**WEST SUSSEX COUNTY COUNCIL
STRATEGIC PLANNING CONSULTATION**

SUBJECT: A/41/15/PL - Formation of new vehicular access.

'Merrivale', Station Road, Angmering, West Sussex, BN16 4HY

SITE PLAN 1:200

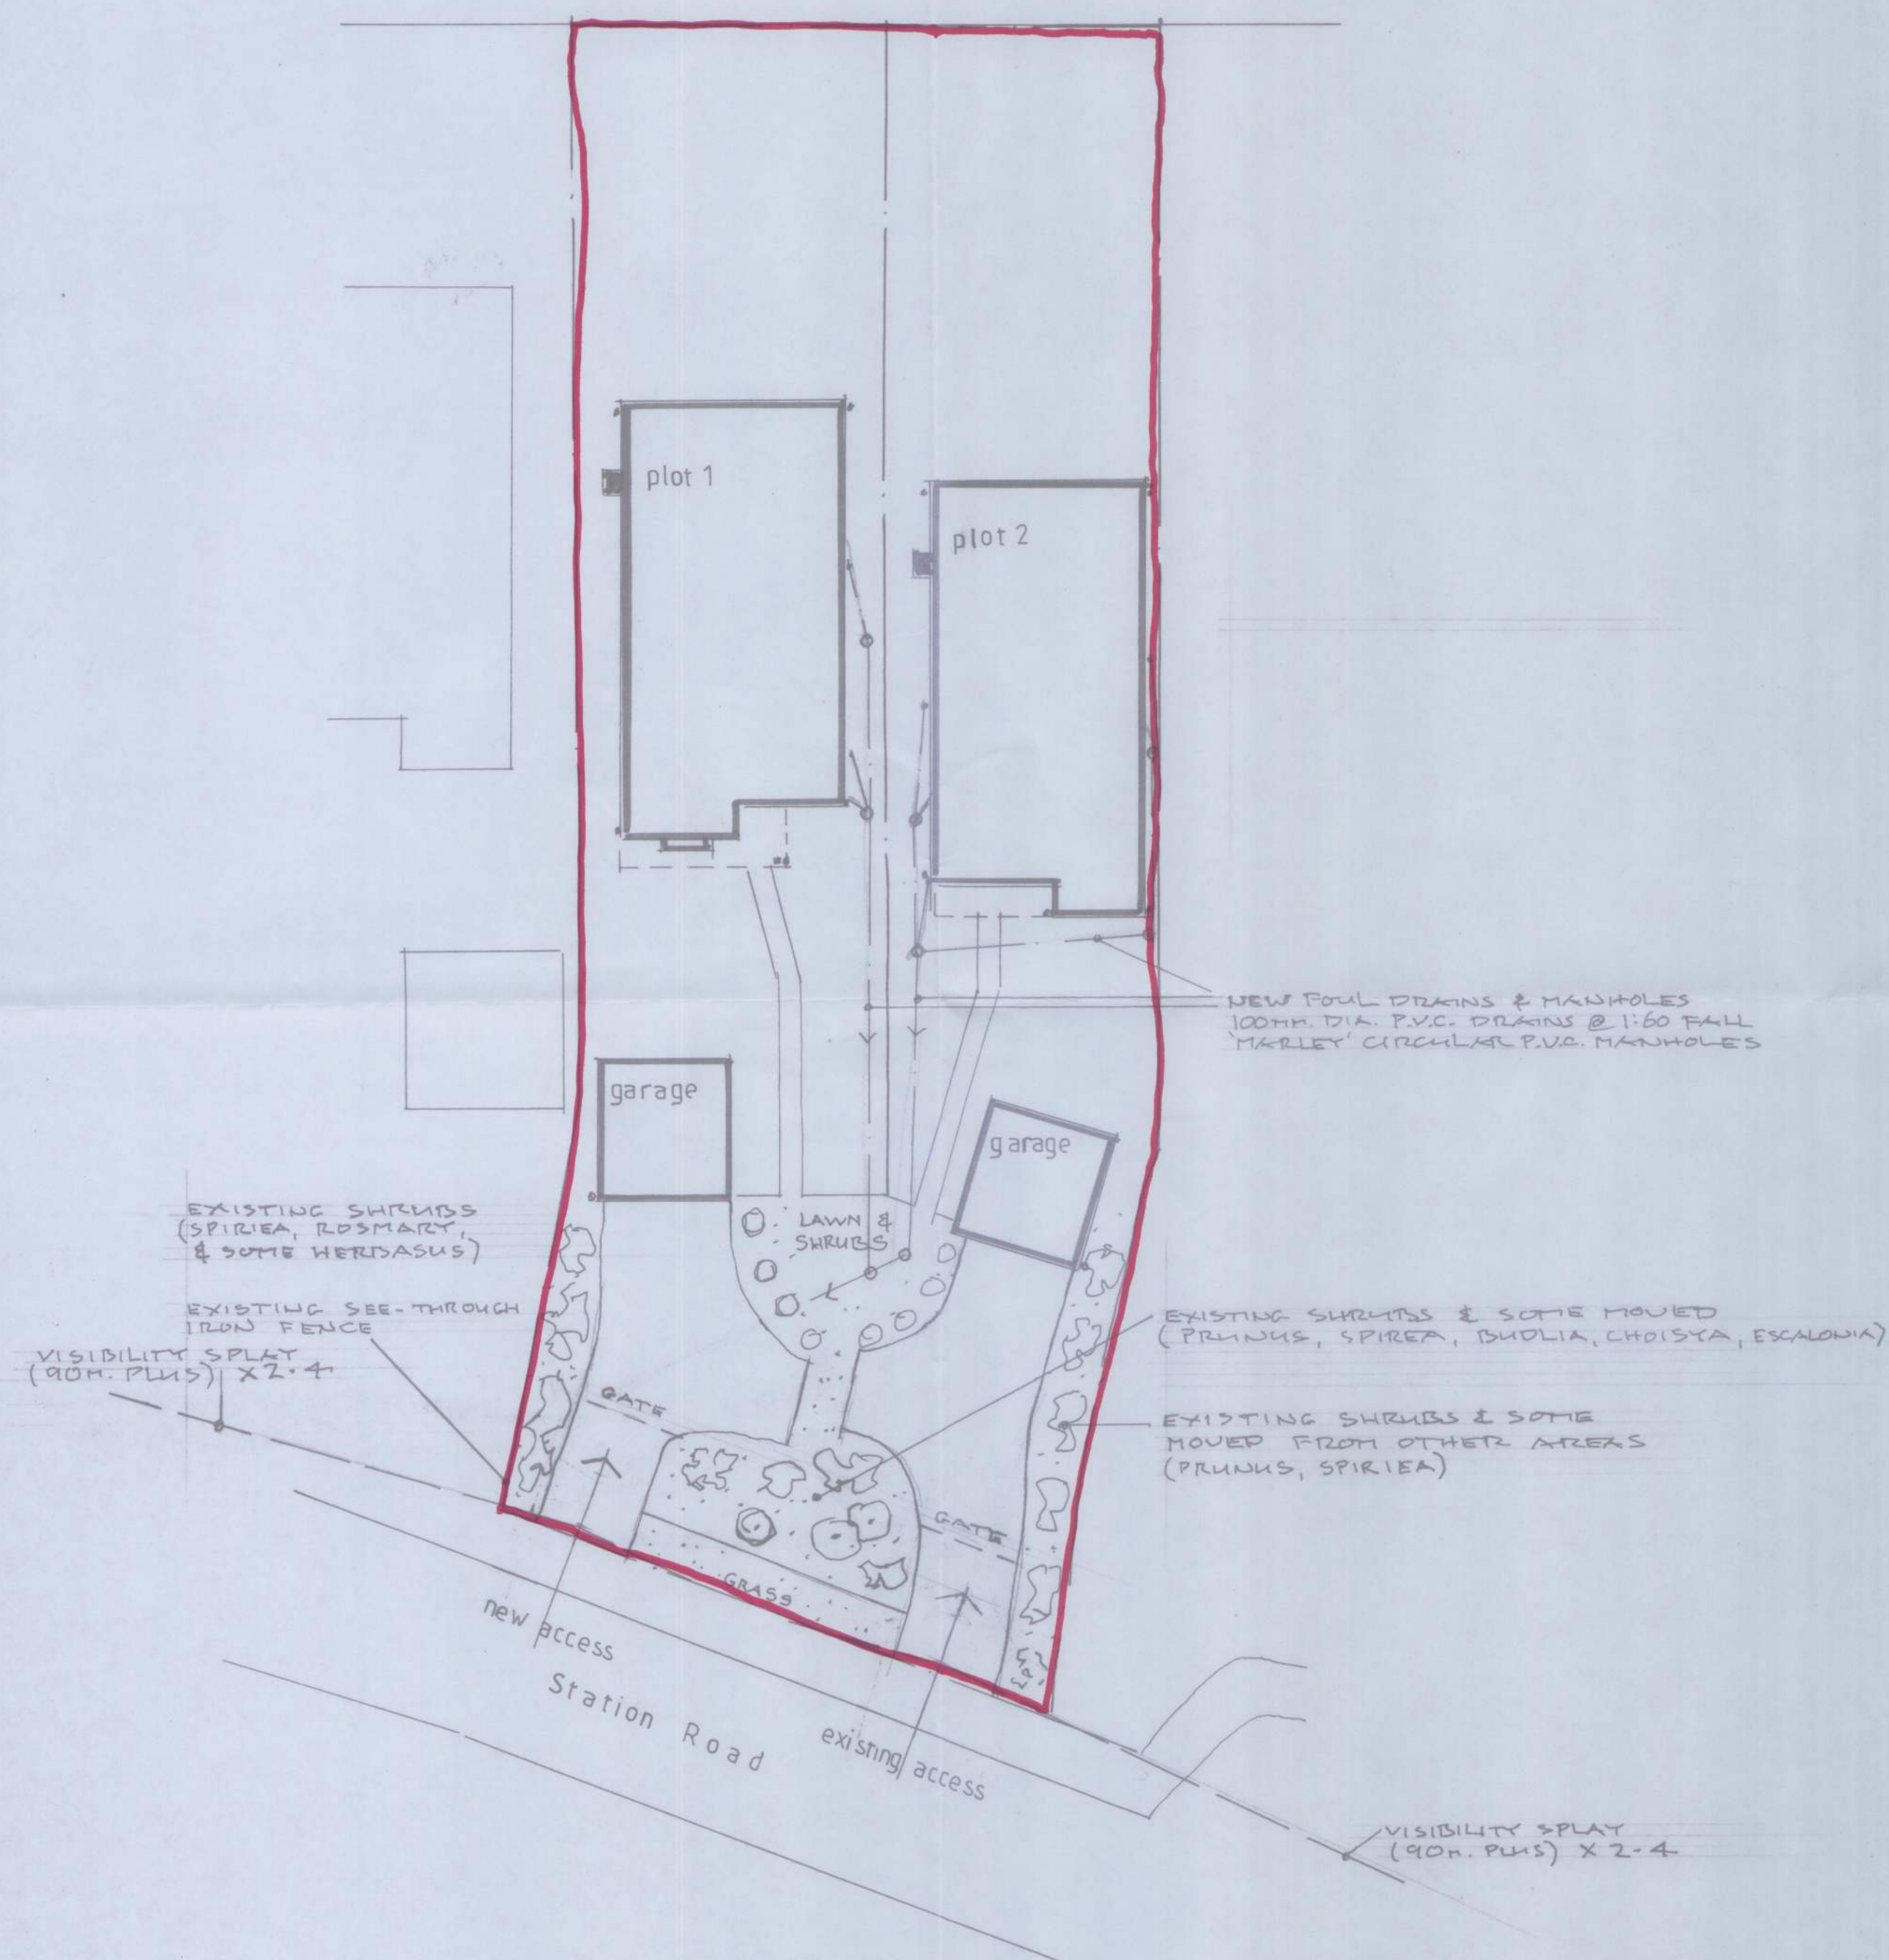
The proposal is for an access serving each 2 proposed dwellings onto Station Road. From an inspection of the plans alone, there is no apparent visibility issue at the point of access onto Station Road. The most recently available verified accident records reveal there have been no personal injury accidents in the vicinity of the existing point of access, indicating a low risk of highway safety issues with this proposal.

No part of the development shall be first occupied until visibility splays of 2.4 metres by 90 metres have been provided at the proposed site vehicular access onto Station Road in accordance with the approved planning drawings. Once provided the splays shall thereafter be maintained and kept free of all obstructions over a height of 0.6 metre above adjoining carriageway level or as otherwise agreed.

No part of the development shall be first occupied until the vehicle parking and turning spaces have been constructed in accordance with the approved plan. These spaces shall thereafter be retained for their designated use.
